CITY OF ALBUQUERQUE

September 30, 2014

**Re: Noah's at Fountain Plaza
Grading and Drainage Plan
Engineer's Stamp Date 9-15-14 (C12D003B4)**

FOR INFO ONLY	ENGINEER'S SEAL	NOAH'S EVENT CENTER	DRAWN BY DEM
			DATE
		CONCEPTUAL GRADING AND DRAINAGE PLAN	5-2014
			visitors must comply with all rules
			SHEET #
			3 of 6
			JOB #
			5844.86

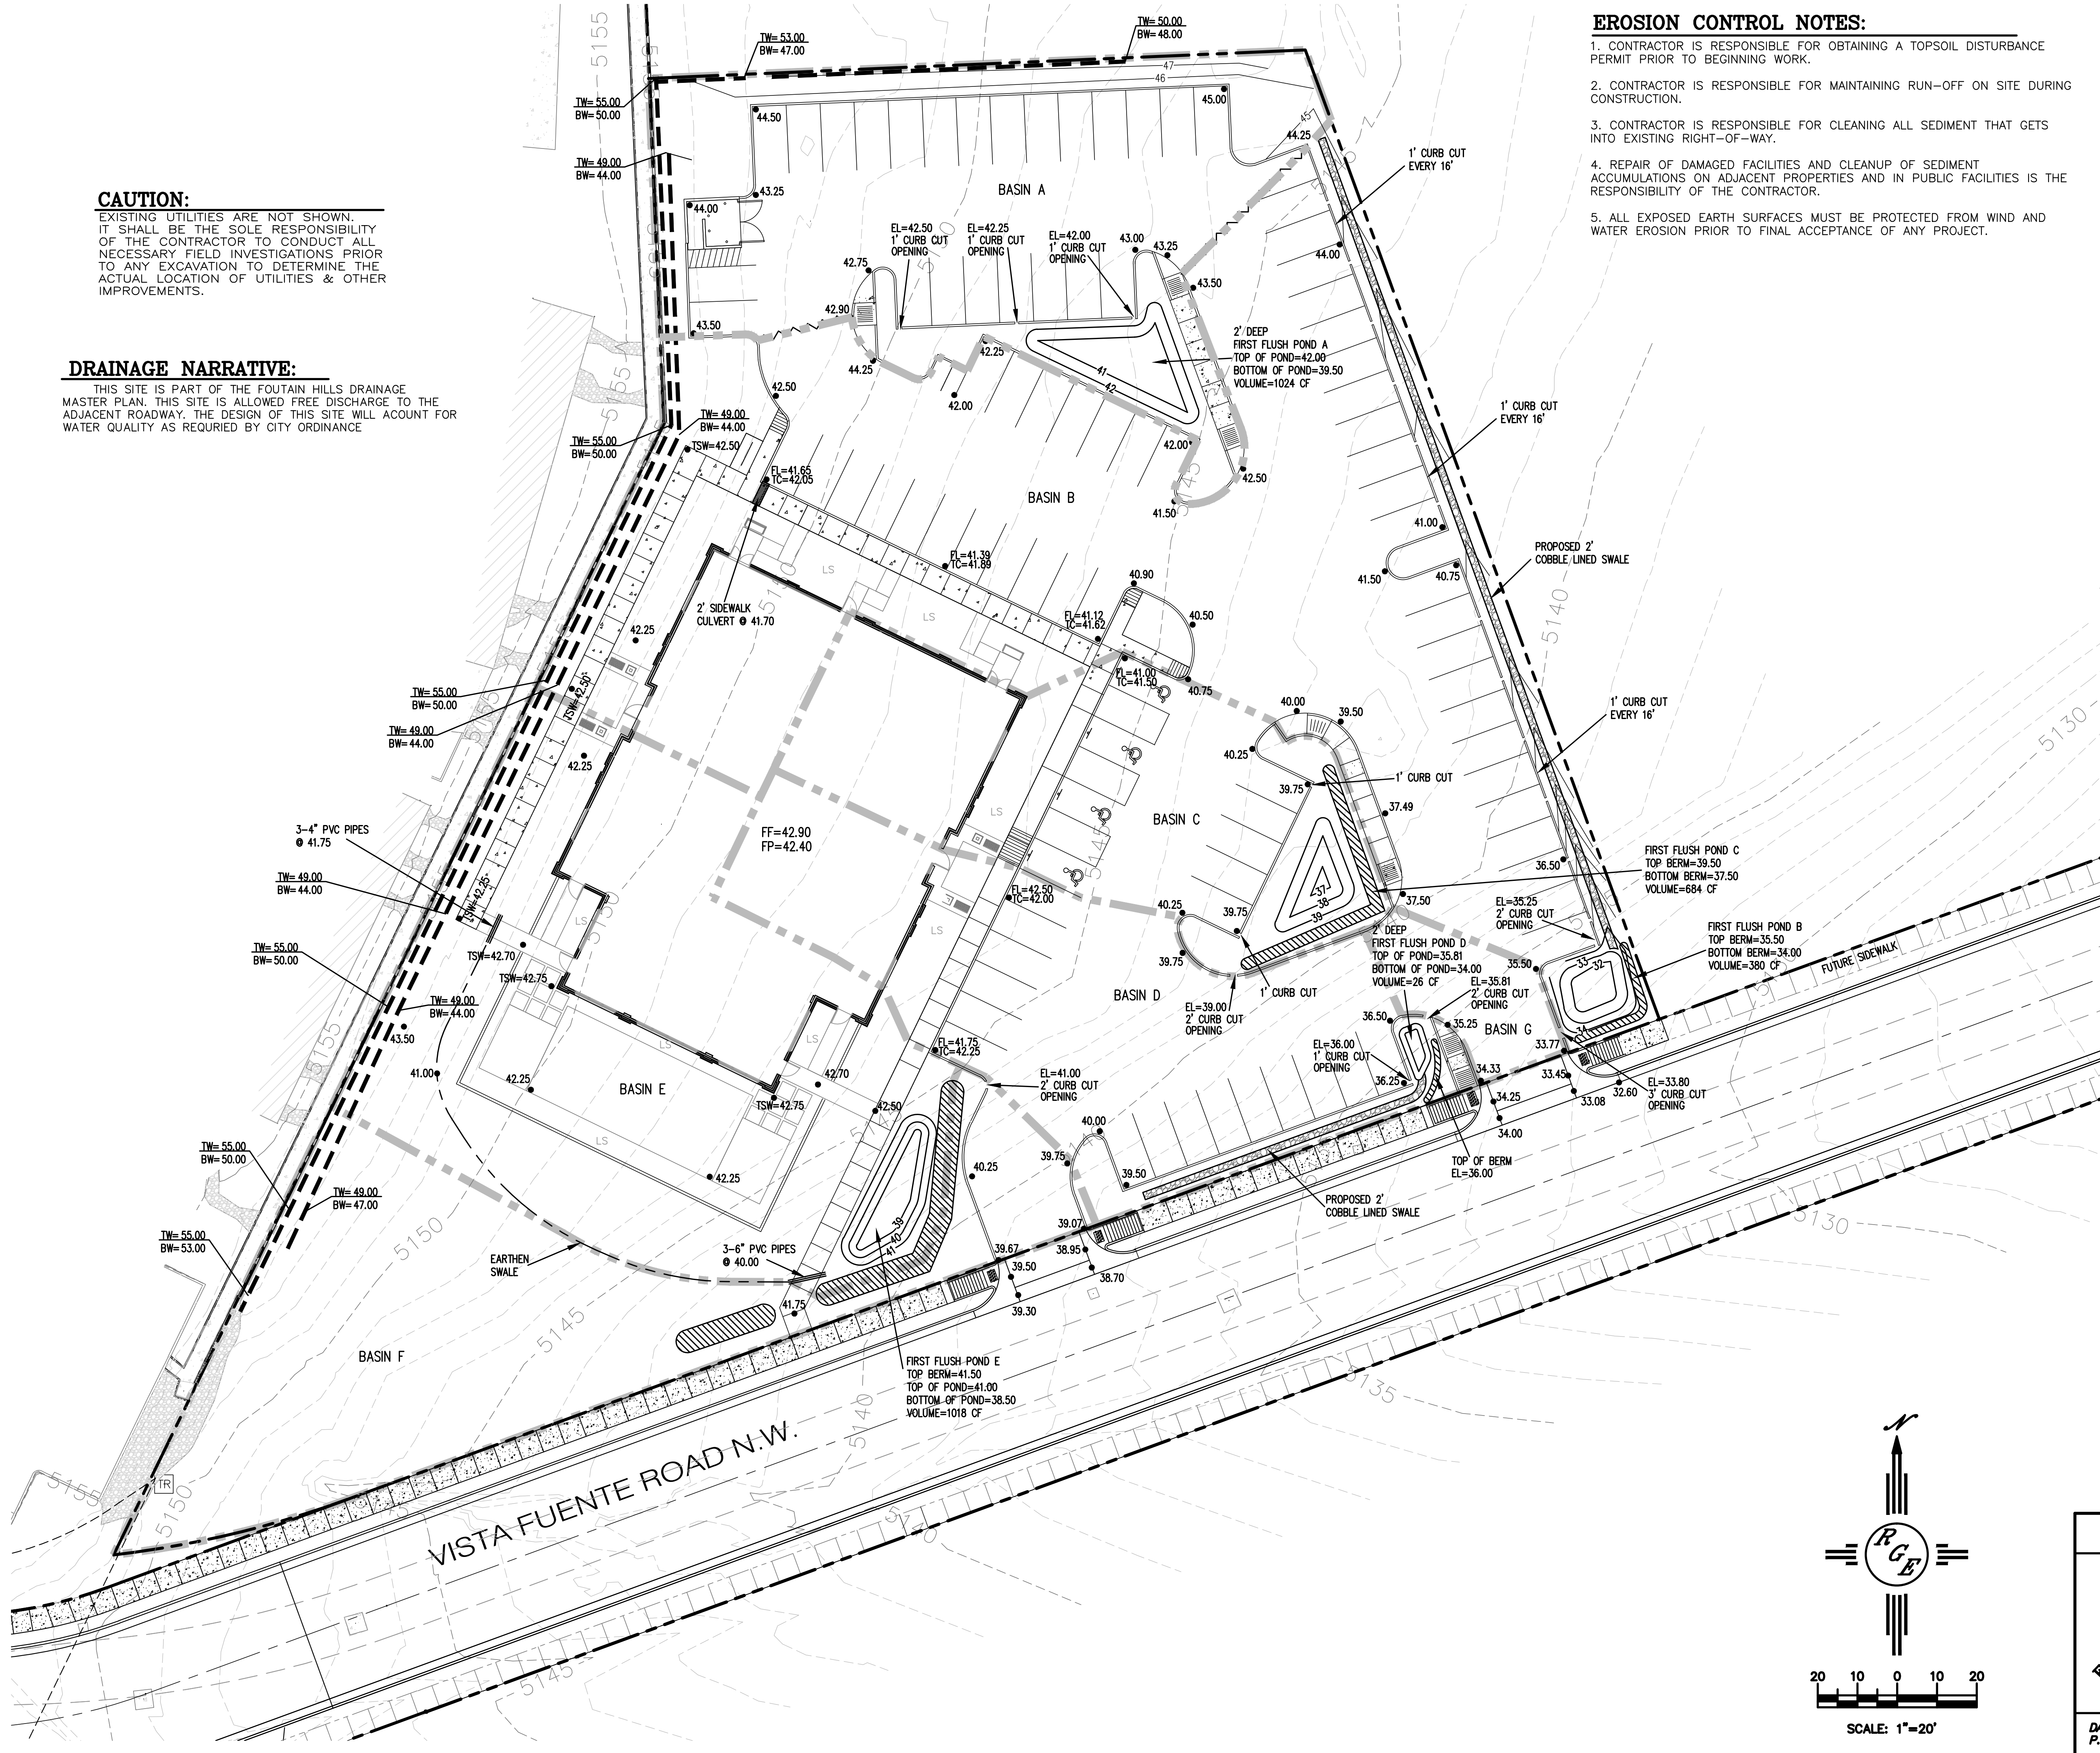
3. The contour elevations of the First Flush ponds do not match what is being called out in the text for the ponds. Please revise.
4. How is the site tying into exiting grades along the perimeter? Provide contours or spot elevations showing how that is being accomplished.

5. Provide bottom of wall elevations where sidewalk elevations are called out.
6. Include calculations showing the 18 inch laterals are sufficiently sized.
